From: Emmett, Rachel - 11414 [Rachel.Emmett@lancashire.pnn.police.uk]
Sent: 18 July 2012 16:00
To: Graeme Thorpe
Subject: RE: RE - Proposed office development on site adjacent to Myerscough Road, Mellor Brook - 3/2012/0269/P [NOT PROTECTIVELY MARKED]

Due to the limited timescale I have not had time to prepare a full report but my brief observations are as follows;

campbell driverpartners
 architects designers surv
 client: leehand properties ltd
 project: office development
 A59 Mellor Brook
 sheet: site plan

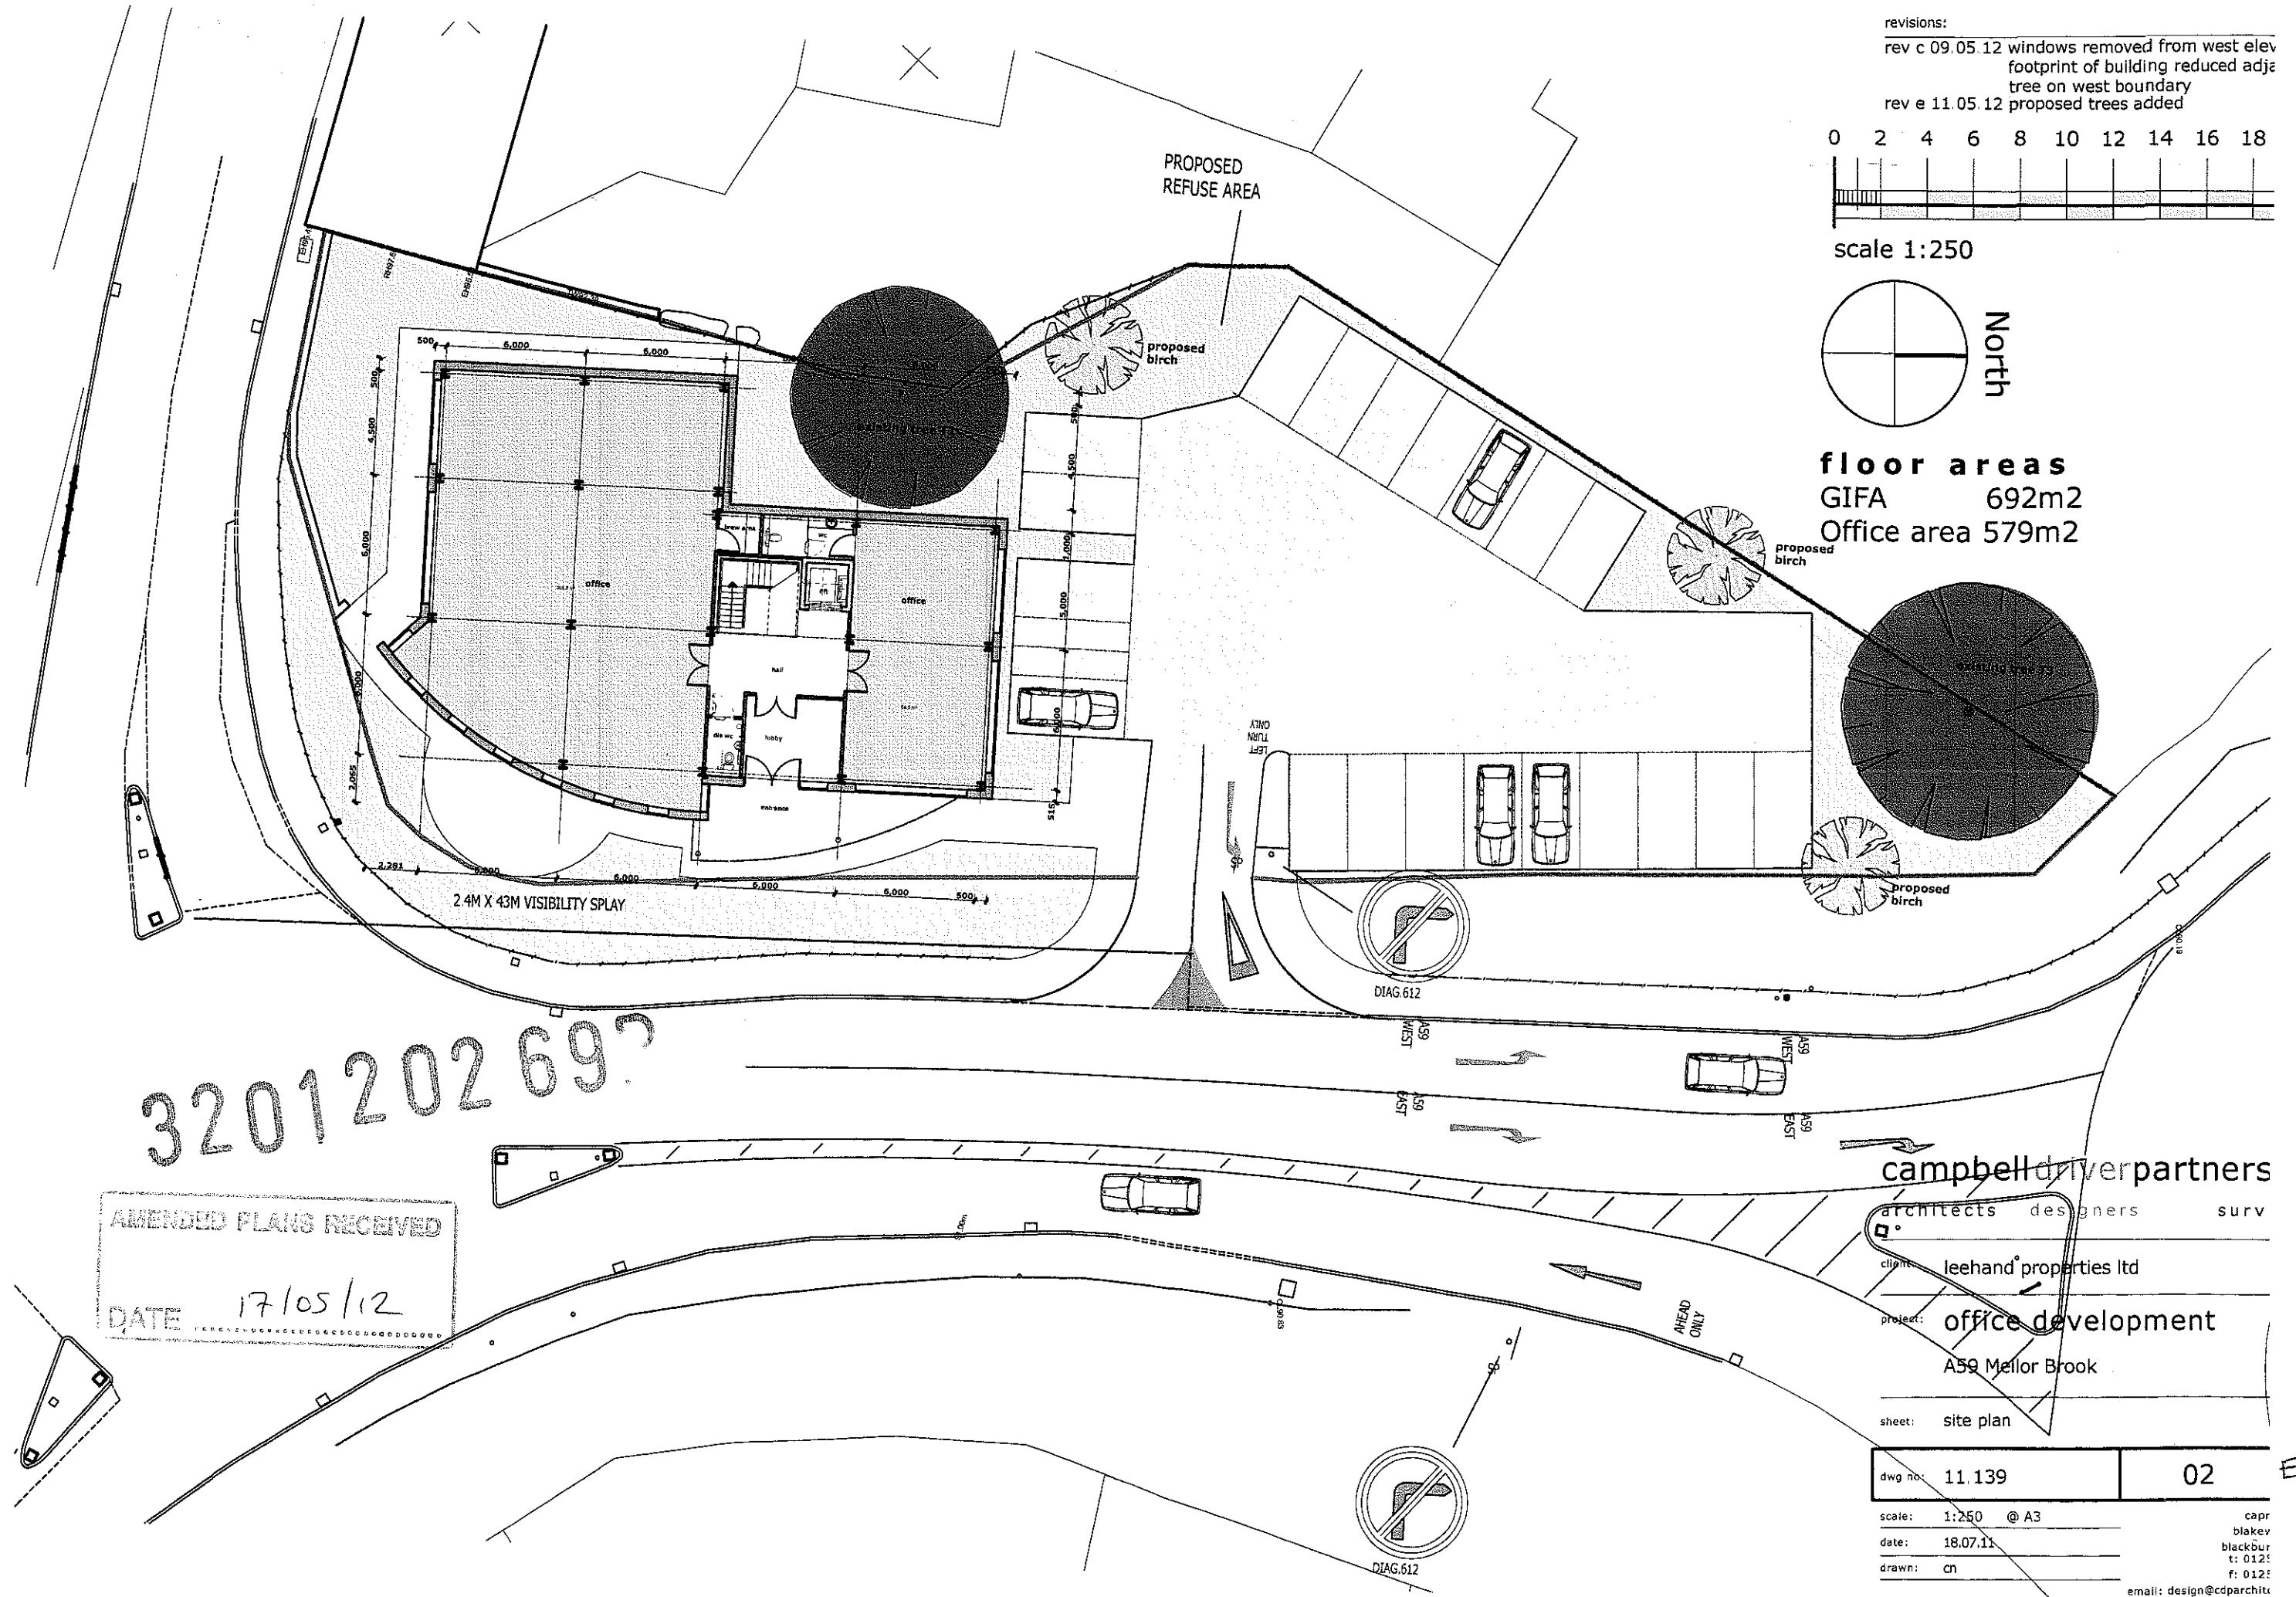
Landscaping – the Design and Access refers to the use of 'semi-mature trees, hedge planting and naturalised shrub planting around the car parking and entrance areas'. I would recommend that low level shrubs only are used (less than 1m high when mature) so they do not impede sight lines and prevent natural surveillance of the car park/entrance. If higher level planting is used which obstructs the view of the car park, it is likely that car crime will soon take hold. I would further advise the use of defensive (thorny) planting to form the perimeter boundary to the east and south of the site.

Lighting- it is unclear what the proposed lighting scheme would involve. I would advise that the north, east and south elevations and car parks are covered by a lighting scheme of columns using high pressure sodium vapour which illuminates the elevations as well as the walkways for security of the building and safety of the users.

sheet: scheme layout

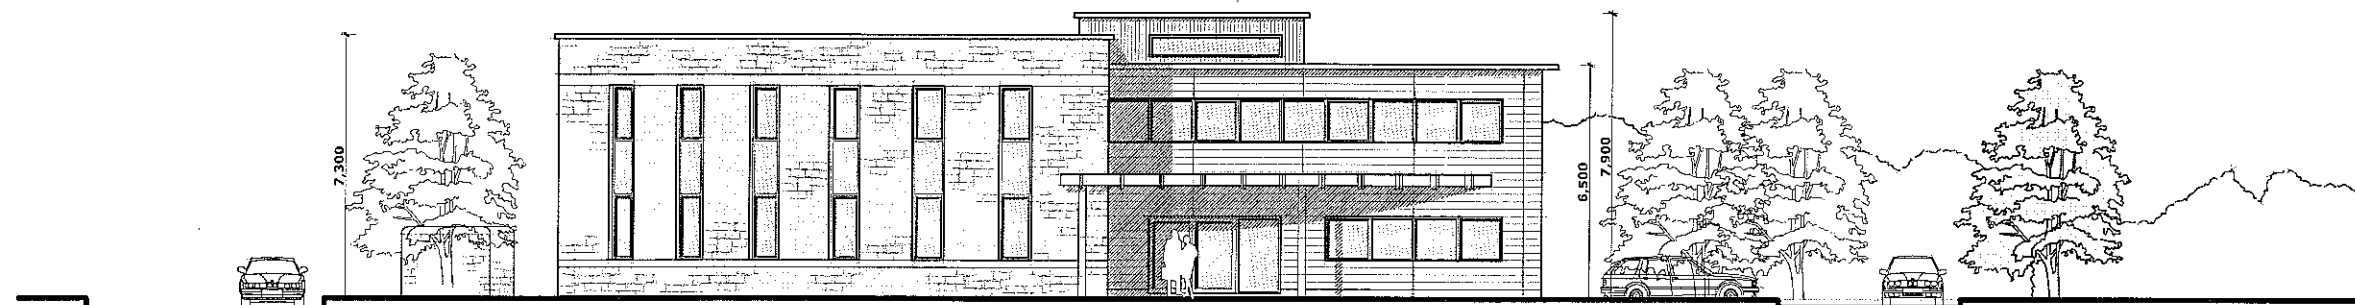
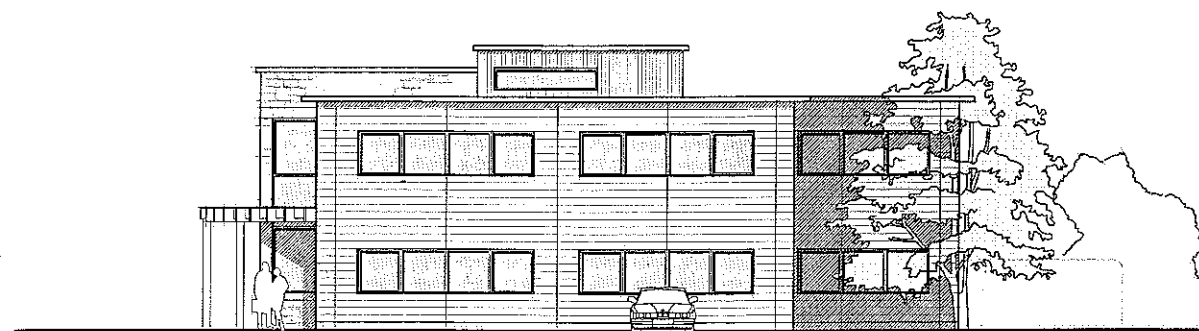
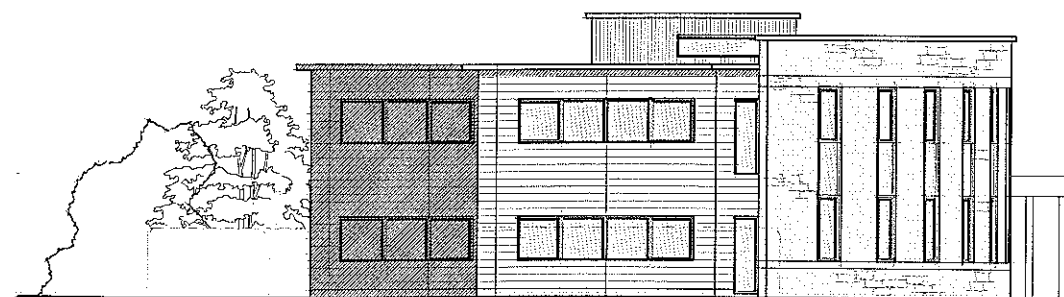
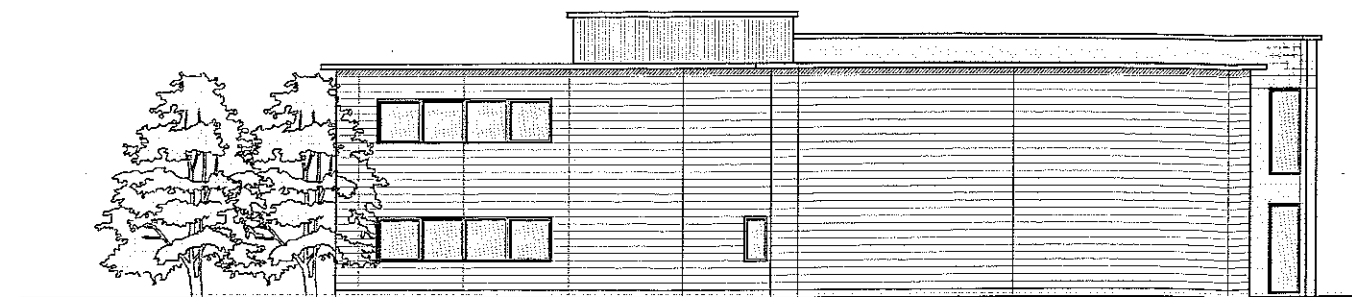
Security- the intended use of low level bollard lighting will enhance visibility and promote a feeling of safety. I would advise that the premises be fitted with an alarm connected to a monitoring station or that core wiring for an alarm system is installed due to the rural location and the IT equipment likely to be on the development. I would further advise the installation of security lighting to the rear elevations (west on the plans) and a CCTV within the lobby/hall areas.
